CITY OF ALBUQUERQUE

July 16, 2015

**RE: Dreamstyle Warehouse, 1525 Renaissance Center
Grading and Drainage Plan
Engineer's Stamp Date 7-15-2015 (File: F16-D051A)**

ENGINEER'S SEAL	TRACT 9A RENAISSANCE CENTER	DRAWN BY BJF
	GRADING AND DRAINAGE PLAN	DATE 7/20/15
RONALD B. BOHANNAN P.E. #7868	 TIERRA WEST, LLC 5571 MIDWAY PARK PLACE NE ALBUQUERQUE, NM 87109 (505) 858-3100 www.tierrawestllc.com	SHEET # D1
		JOB # 2015009

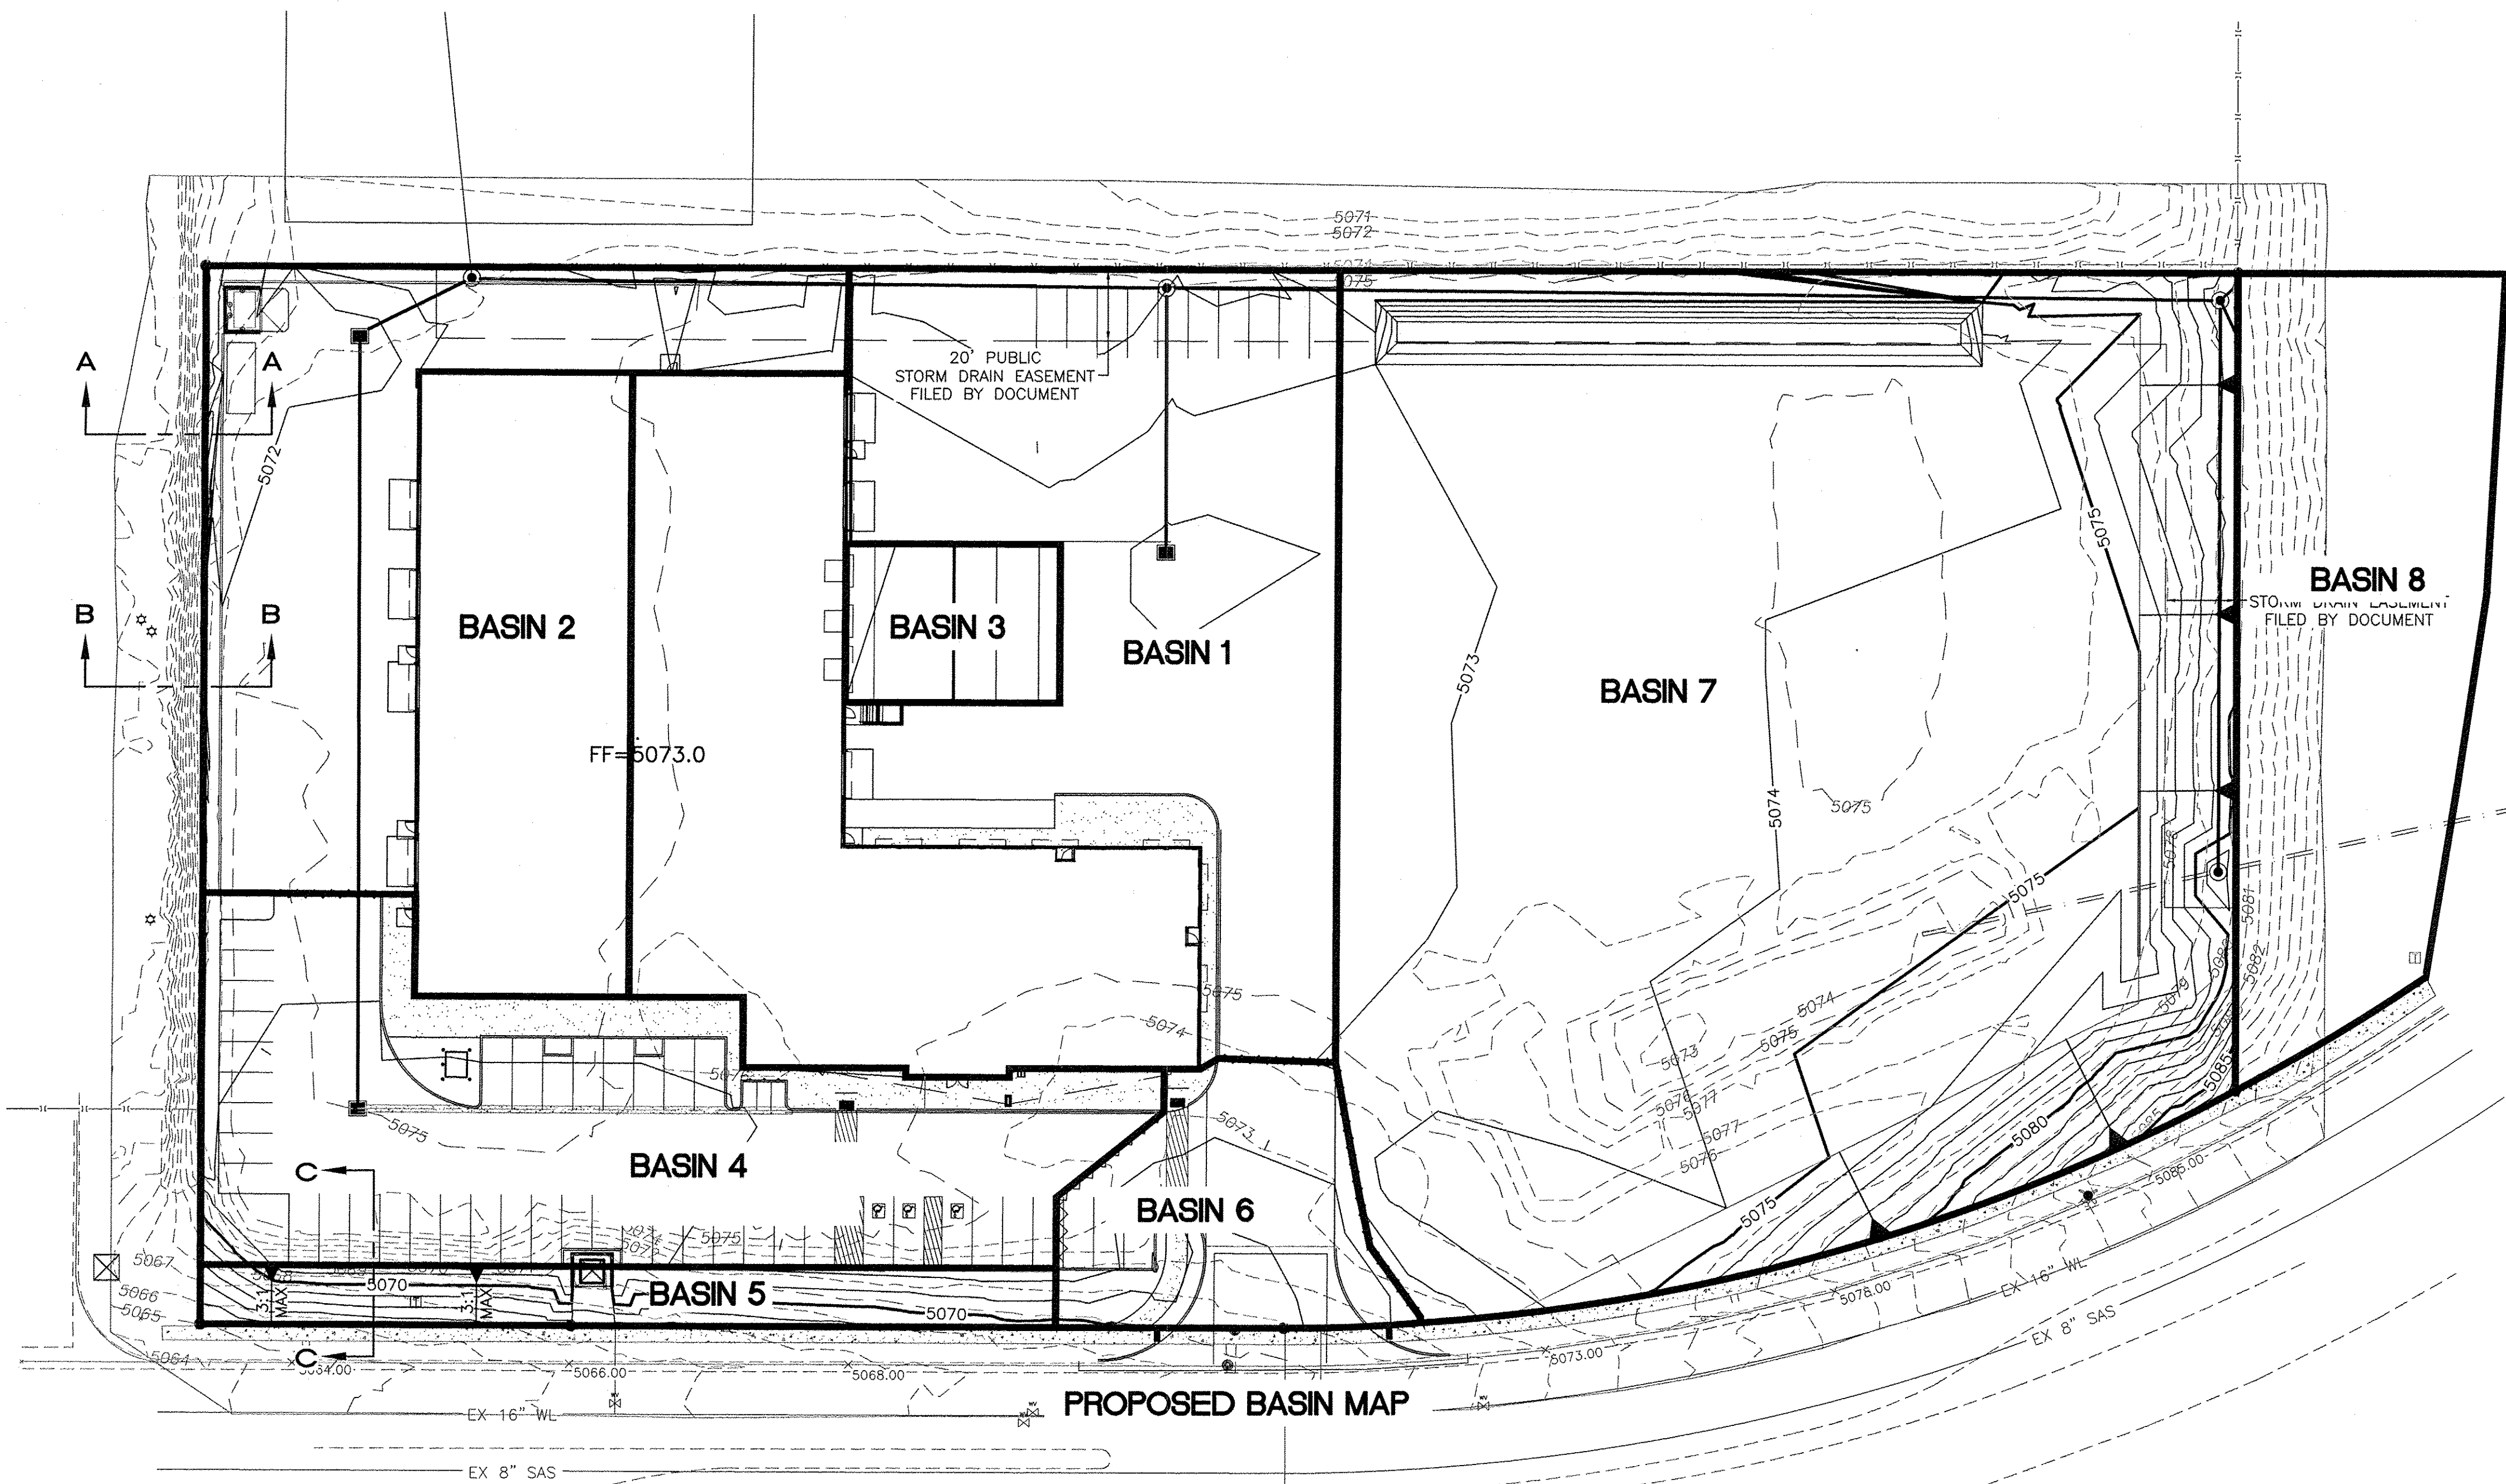
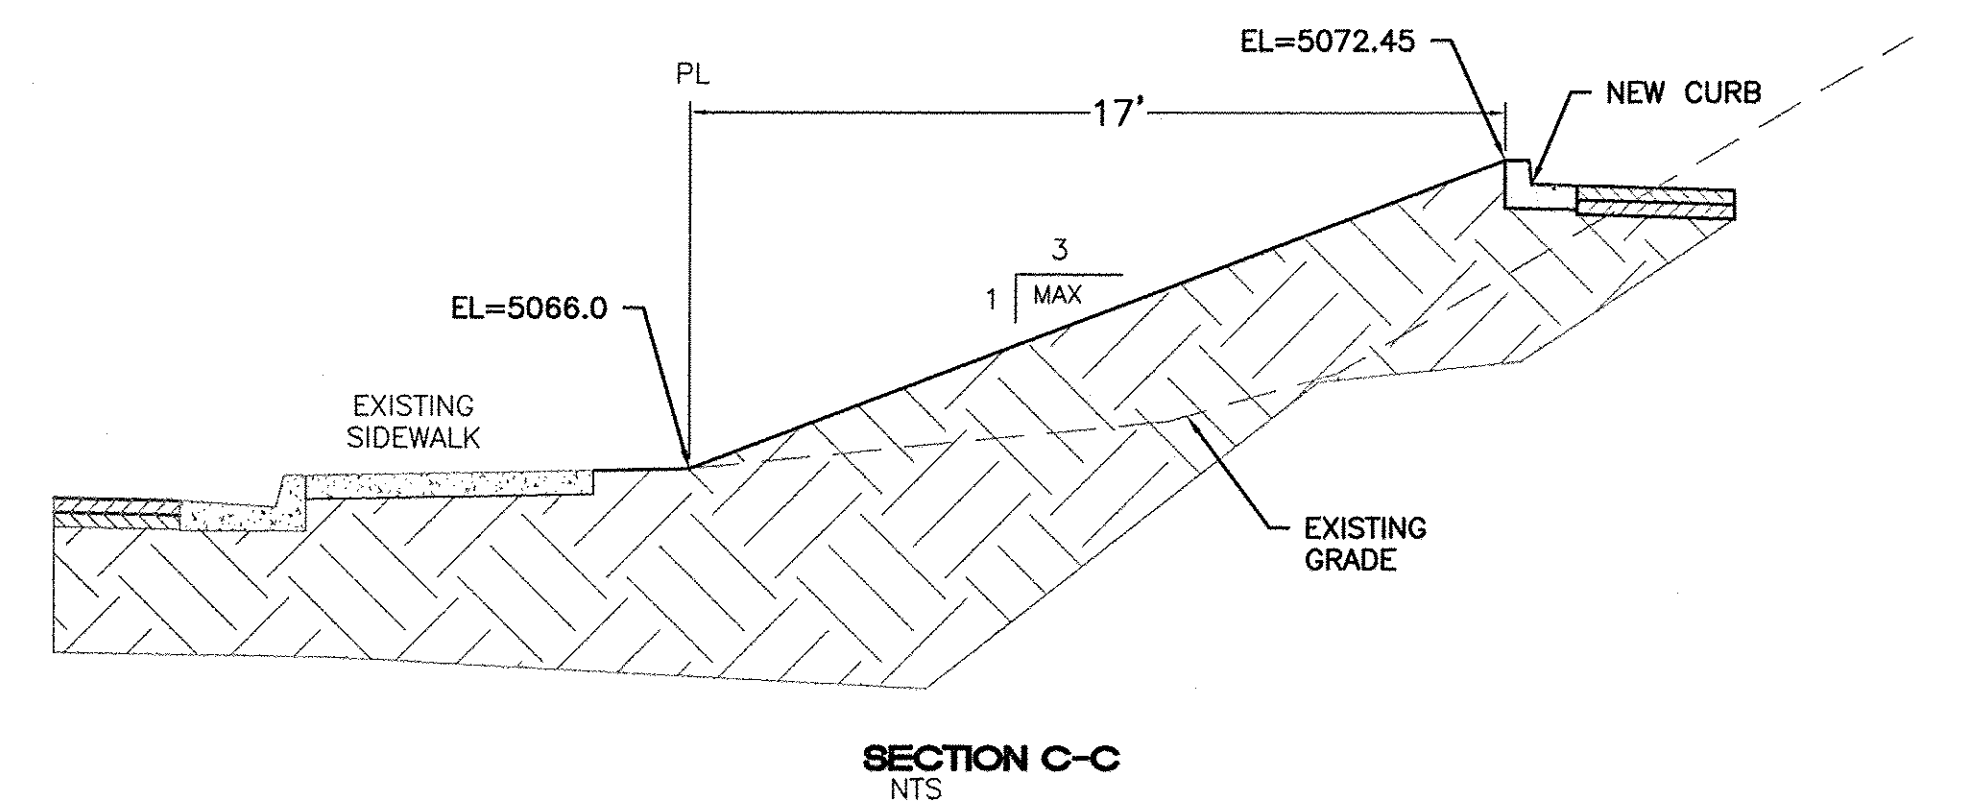
- 1) The drainage easement per the provided plat covers surface drainage only. A separate paper easement is required for the underground proposed storm drain that routes flows from off-site. Show the new easement on the grading and drainage plan.
- 2) On a more minor note, the water block labels need to be revised to point to the new waterblock location near the new entrance. Make sure that both the single D inlet from the previous submittal and the new double D inlet calculations are shown on the newest plan.
